Arun District Council
Arun Civic Centre
Maltravers Road
Littlehampton
West Sussex BN17 5LF
Planning & Building Control General Enquiries
Tel: (01903) 737756 Fax: (01903) 730442
Dx: 57406 Littlehampton
Minicom: 01903 732765
e-mail: planning@arun.gov.uk
website: www.arun.gov.uk/planning

Application No: Y/10/22/PL
Site Address: Land to the south of Ford Lane and east of North End Road Yapton BN18 0DS
Description of works: Erection of 15 No dwellings (including 4 No affordable units) with associated access, parking, landscaping, drainage and public open space (additional units to those approved under application Y/123/21/PL). This application may affect the setting of a listed building, affects the character & appearance of the Church Lane Conservation area, affects a Public Right of Way and is in CIL Zone 2 and is CIL Liable as new dwellings.

Thank you for your internet representation made on 9th March 2022 which has been recorded as an objection with the comments as follows:

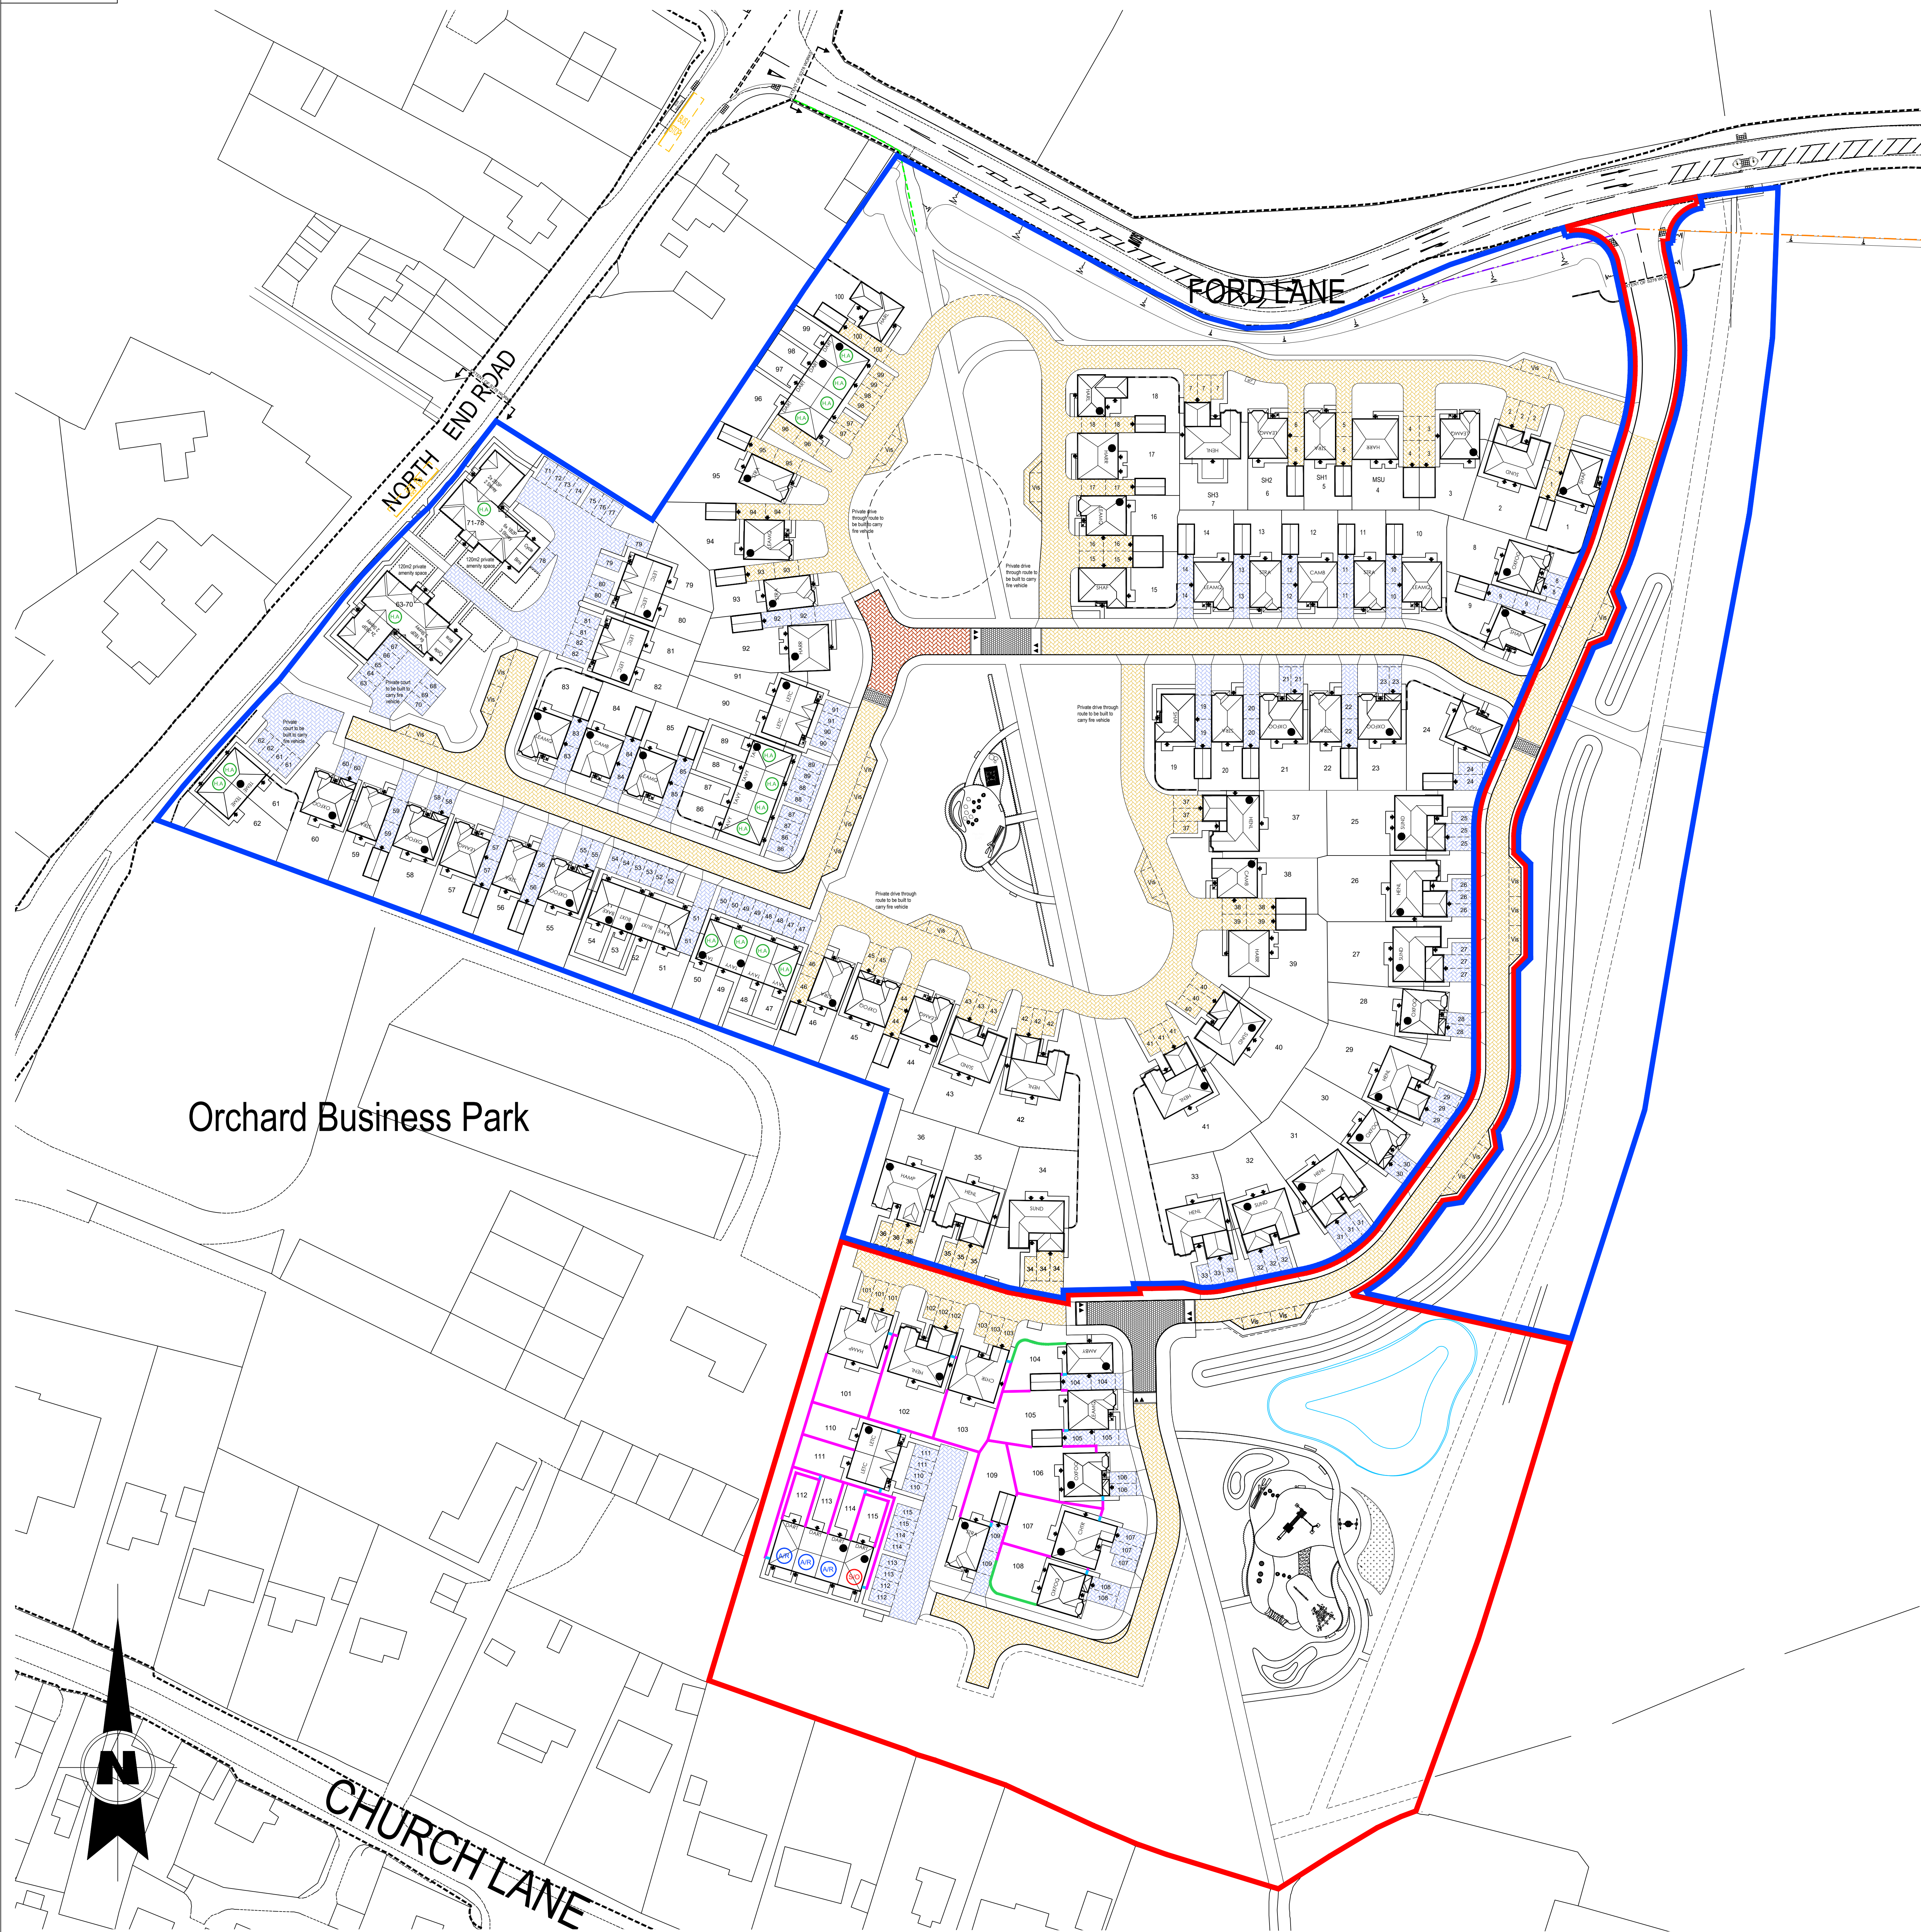
The Western boundary as a whole is given little attention in the application as it is 'bordered by Orchard Business Park'. That simply is not the case for much of the boundary. It borders my house and garden which is sandwiched between this proposed development and Orchard Business Park. The plans and maps that the developers have submitted show my house and garden as part of Orchard Business Park, which is incorrect and misleading.

In the submitted plans, the western boundary line of the site, shown in red, encroaches into my land and the treeline and hedgerows that are claimed as the existing boundary, are my trees and hedgerows. Further, their plans show some trees that are simply not there and cannot be relied upon as a boundary barrier.

Their own drawings show gaps in the existing hedgerow between the development site and my property but no plan is given for the treatment of those gaps other than the vague promise of "a small buffer and boundary hedge". Incidentally, the Ecological Evaluation suggests any such Buffer should be 5 metres wide.

It should also be noted that the house numbered 112, is situated very, very close to an authorised industrial

unit which is frequently noisy. Will the building of these houses lead on to have an adverse impact on the industrial activities of Orchard Business Park and the established local employment opportunities associated therein?
